2 no. new windows to west elevation
12 Chawkmare Coppice Bognor Regis

Thank you for your internet representation made on 18th July 2012 which has been recorded as **an objection** with the comments as follows:

PART GROUND FLOOR. SHOWING
NEW WINDOWS.
[1:50]

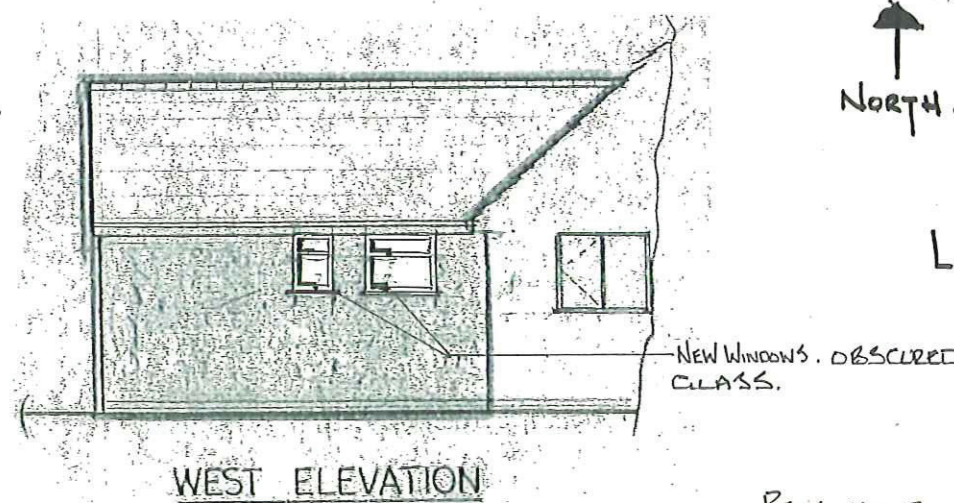
Members object to the application on the following grounds; that the two new windows are un-neighbourly and that they should be constructed using opaque glass. Also, the Members are of the belief that this application appears to be retrospective, the work having already been done. Therefore members agreed that this application is in direct conflict with Policy DEV19 of the Arun District Local Plan 2003.
